QUICK QUACK  
CONSTITUTION

DATE: 14 Jan 2019

PLANTING PLAN  
LP101

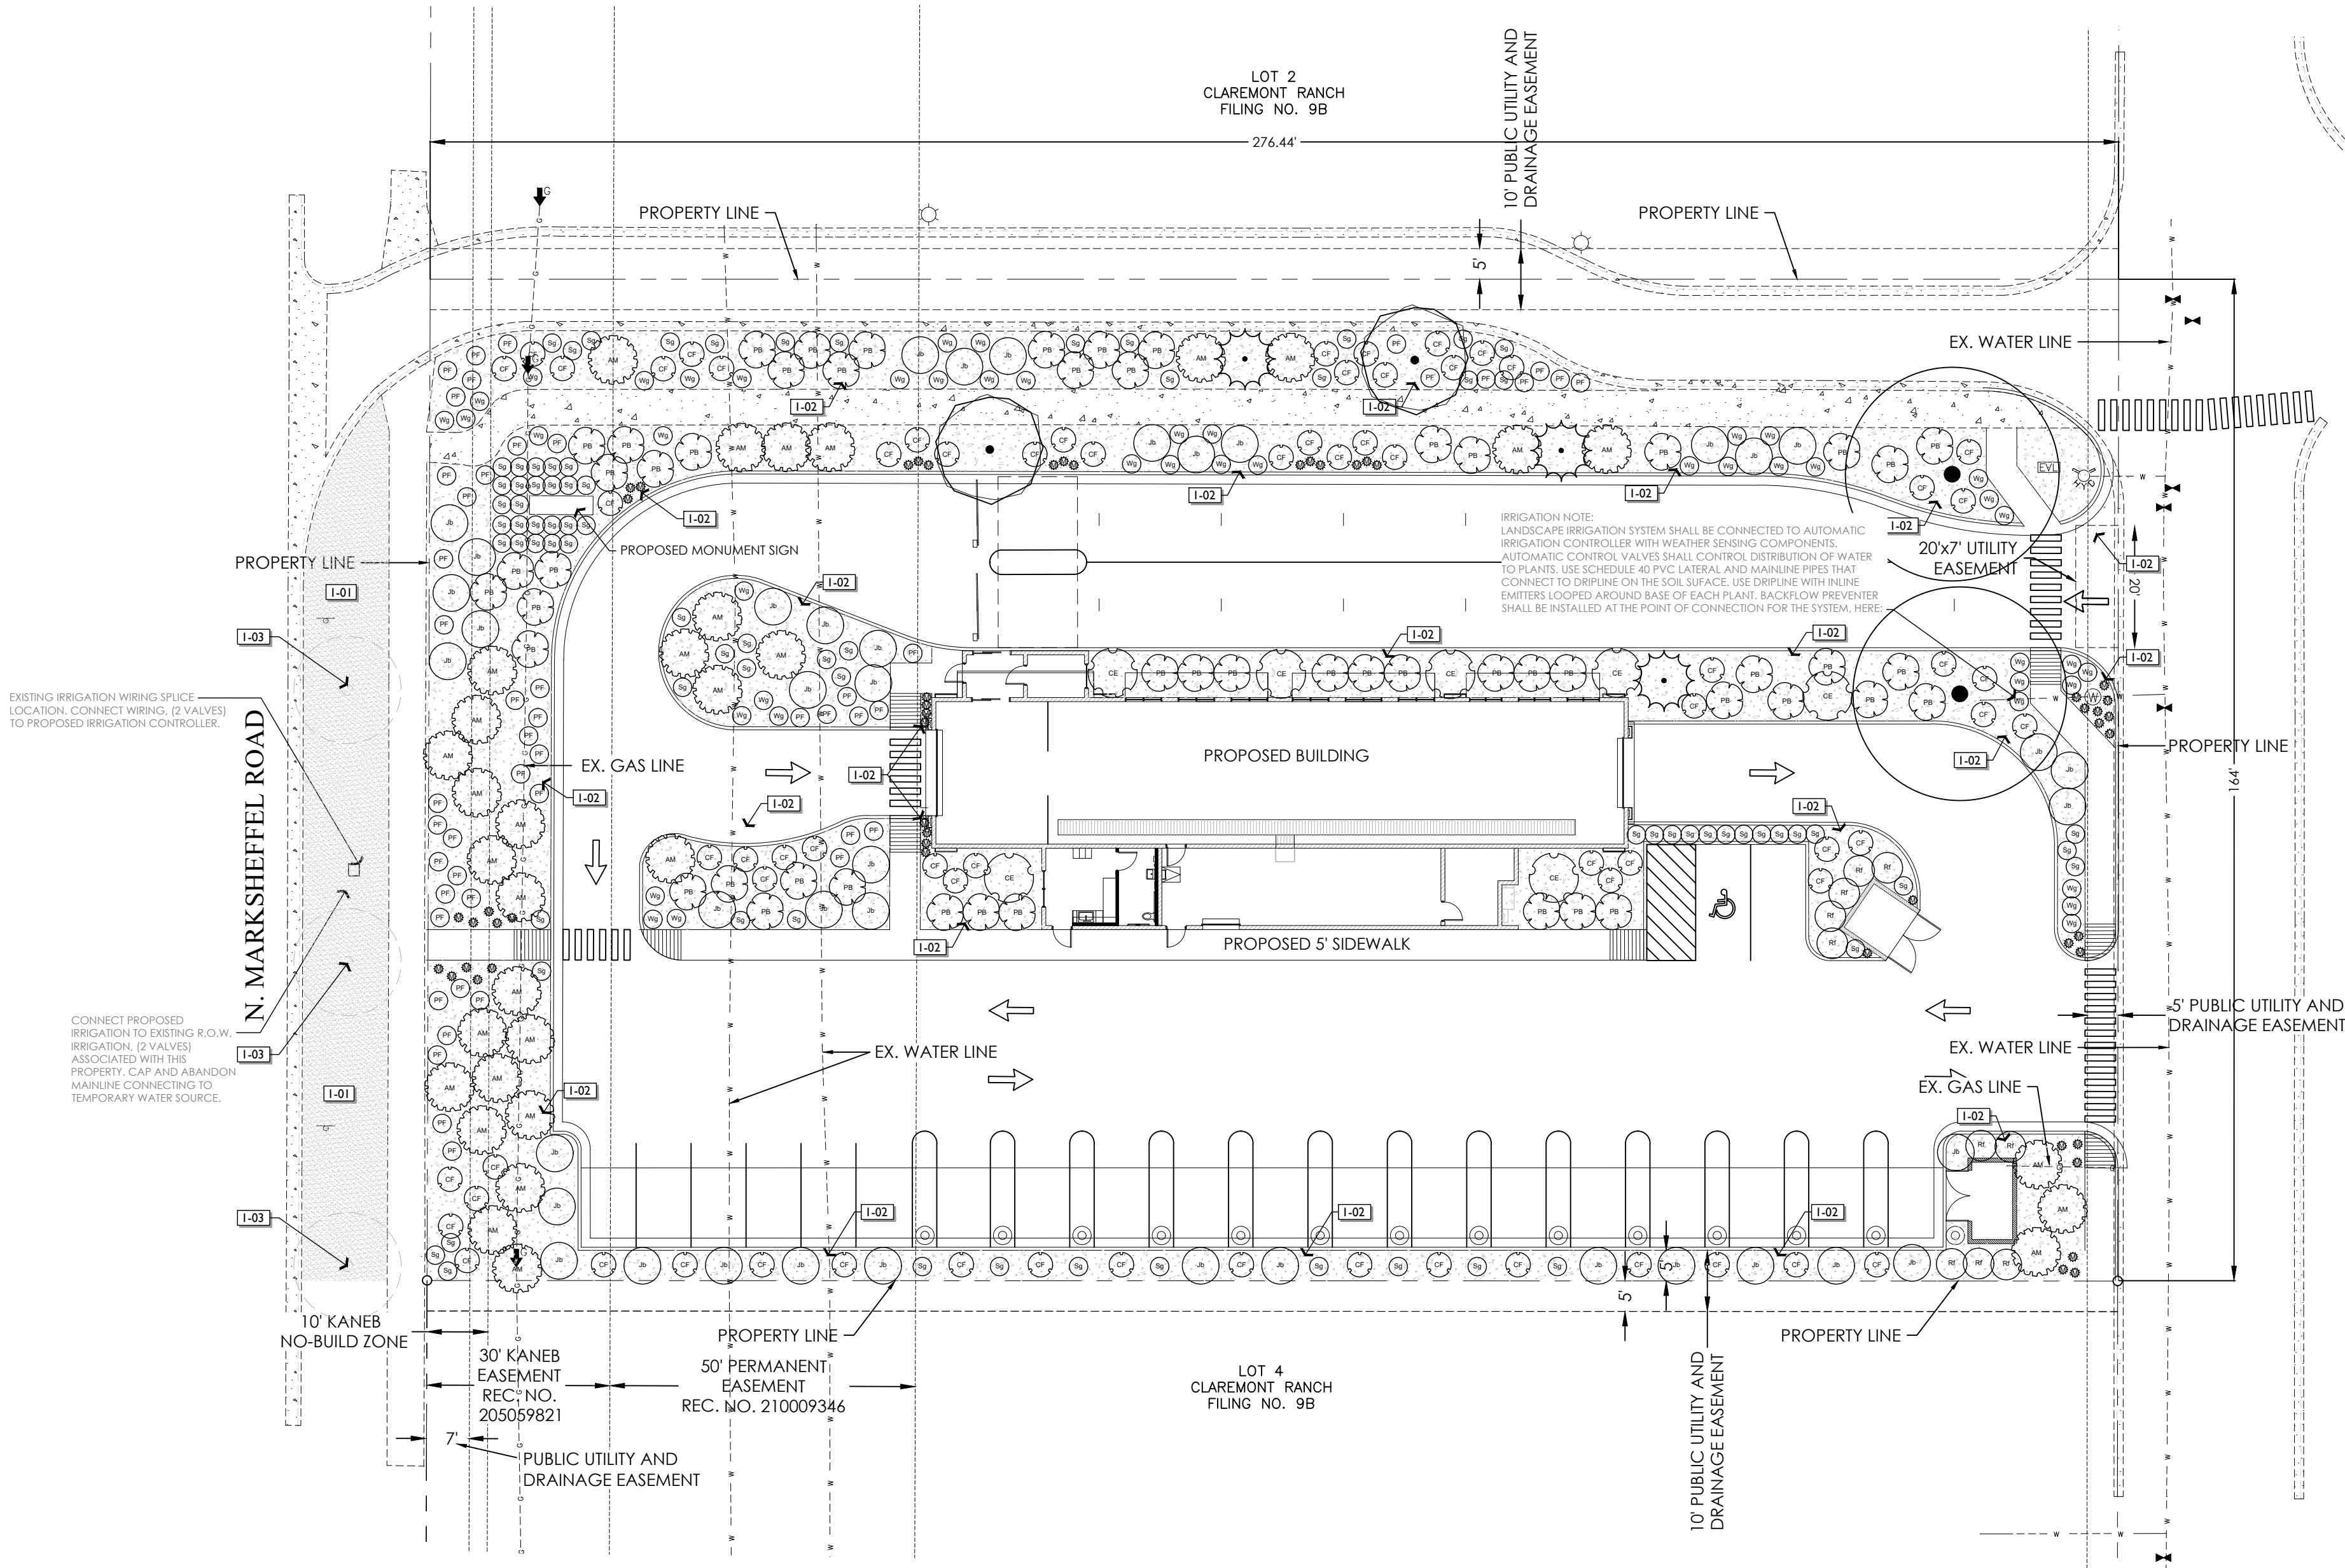
Please indicate property lines, either by labeling or providing a legend on this sheet,

include legend on following sheet, to this sheet, you can shrink the over all depiction down to allow the legend to fit on the same sheet.

North Arrow and legend required, provide distances between property lines, and landscape setbacks.

Please see CSU comment for showing utility easements on landscape plan.

8 trees required along Marksheffel per Section 6.2.2 of the LDC

Also required in the legend is the calculation of the minimum internal landscape area. See Section 6.2.2(E) of the LDC. Show the requirement of 15% then show how much of the internal is actually landscaped.

Include required amount and amount provided.
